CITY OF ALBUQUERQUE

**Re: Arrowwood Hills (Tract 29) Revised Grading Plan
Engineer Stamp 5-11-05 (N9/D8A)**

Based upon information provided in your submittal dated 5-11-05, the above referenced plan cannot be approved for Amended Preliminary Plat until the following comment is addressed.

GRADING & DRAINAGE PLAN

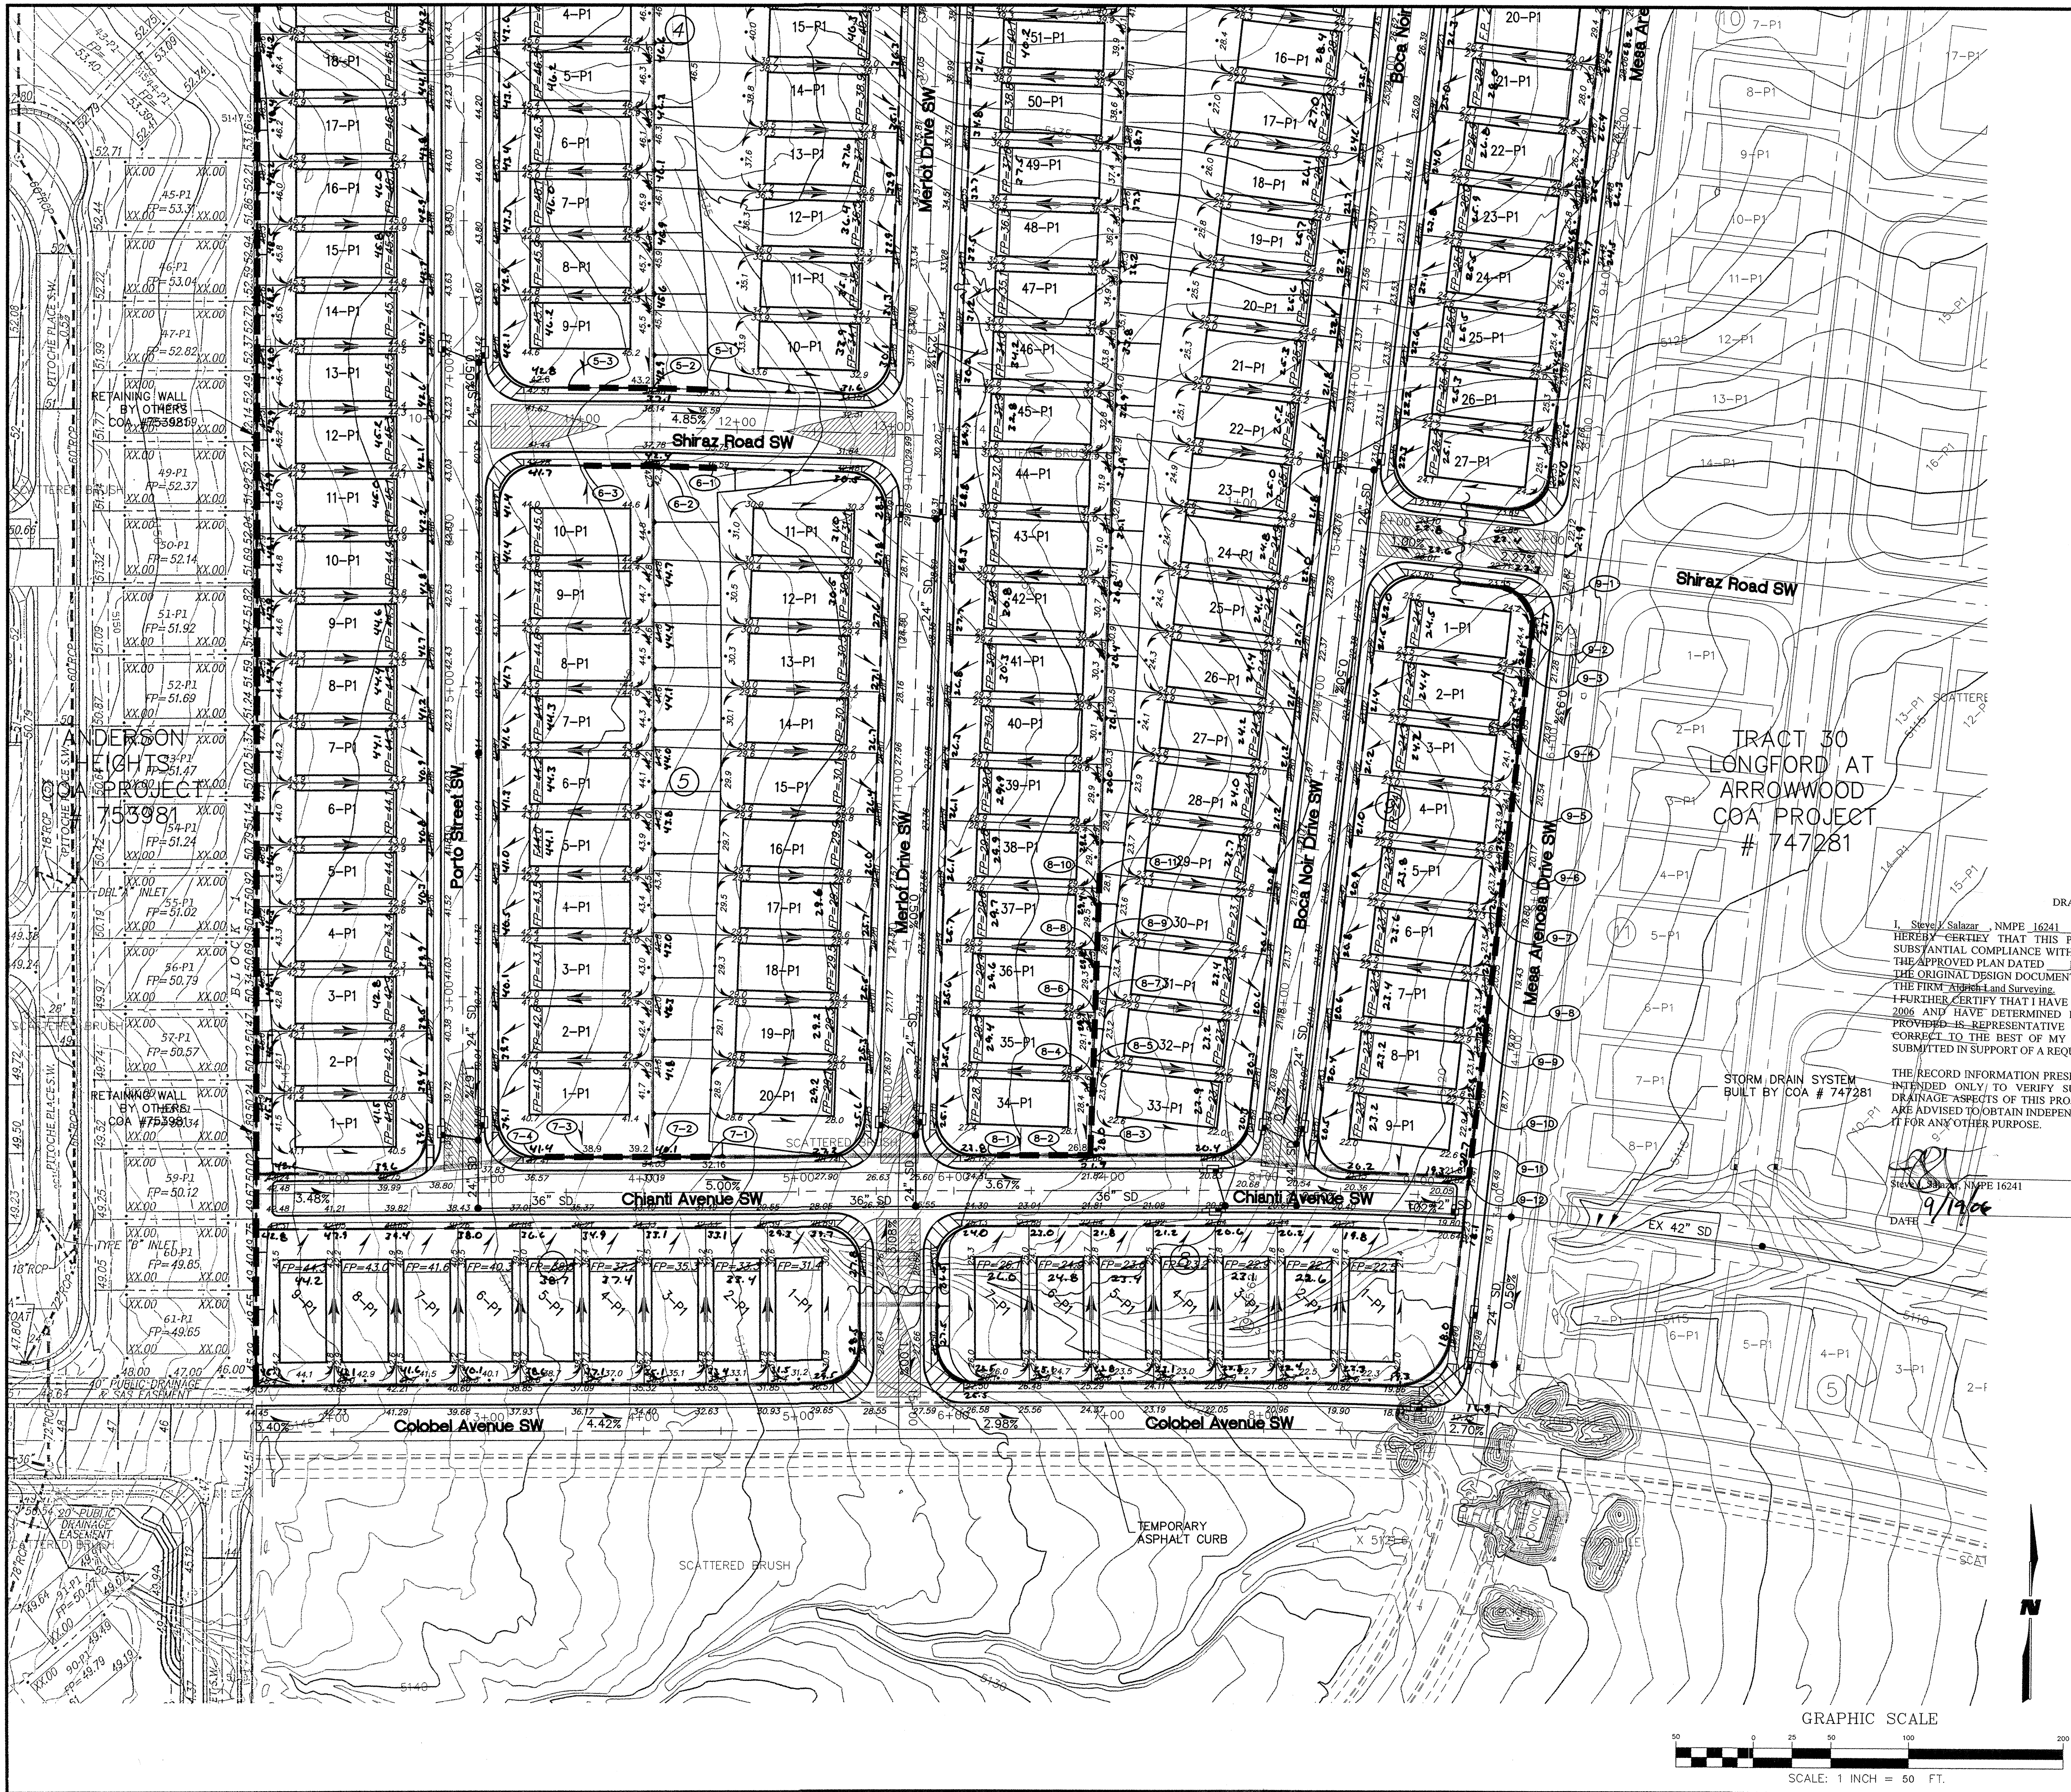
- Comparisons to the grading plans of Anderson Heights adjoining your project show a need for a 4-7' retaining wall that must be shown on your plans. Please coordinate this plan with Greg Krenik of Mark Goodwin and Assoc.
